Arun District Council - Development
Control

Reference: PA-0000287/01
Customer reference: BE/15/26/PL
02 April 2026

Erection of a 3-storey building comprising of under-croft car parking and bicycle store, 2 floors of 4 No self-contained flats on each (8 No flats in total) with pedestrian access formed onto Ash Grove. This application is in CIL Zone 4 (Zero Rated) as flats.

Land East of Heath Place, Bersted, PO22 9SL.

PROPOSED Lower Ground Floor Plan

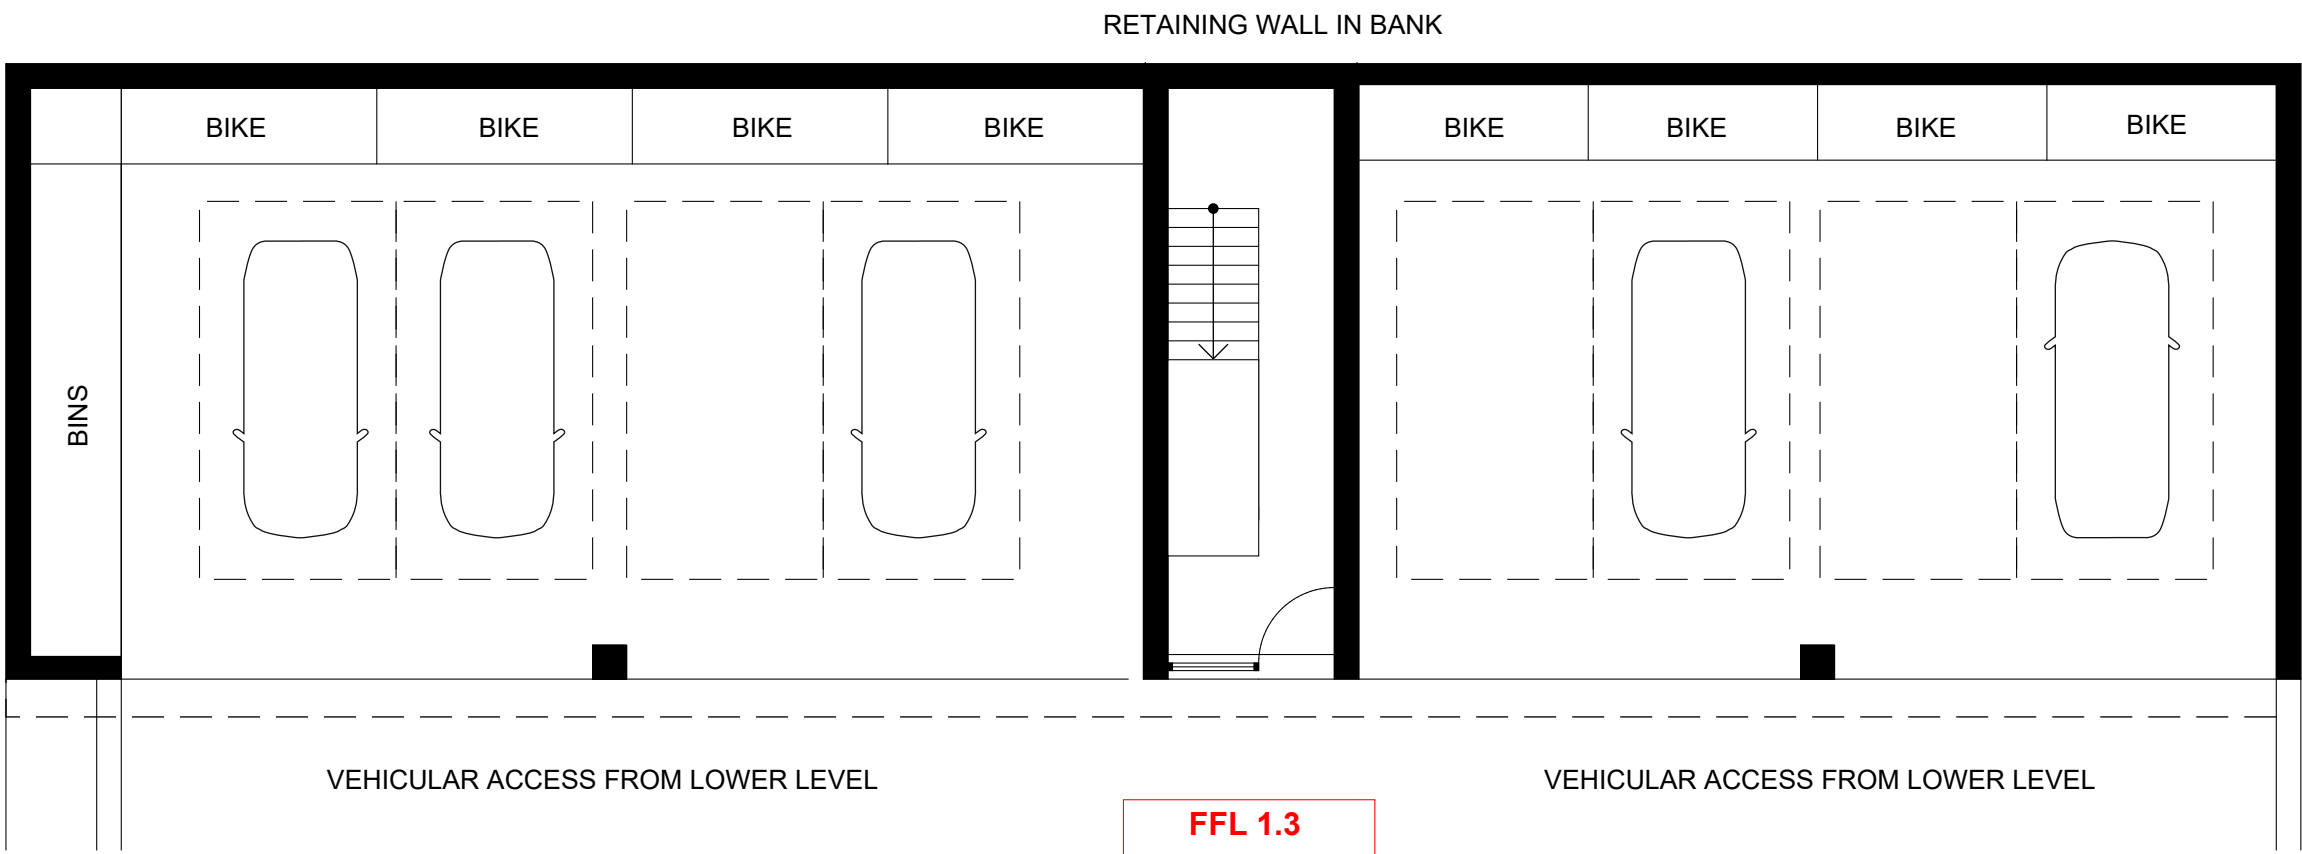
The use of under croft car parking at ground floor level has been proposed at other sites within the Aldingbourne Rife catchment area. Our local position is that, while in some cases they allow water to flow freely and will therefore not be classed as voids,

they do not remove the need for floodplain compensation entirely. Therefore, loss of floodplain area to accommodate large supporting pillars/posts for these structures, should still be adequately compensated.
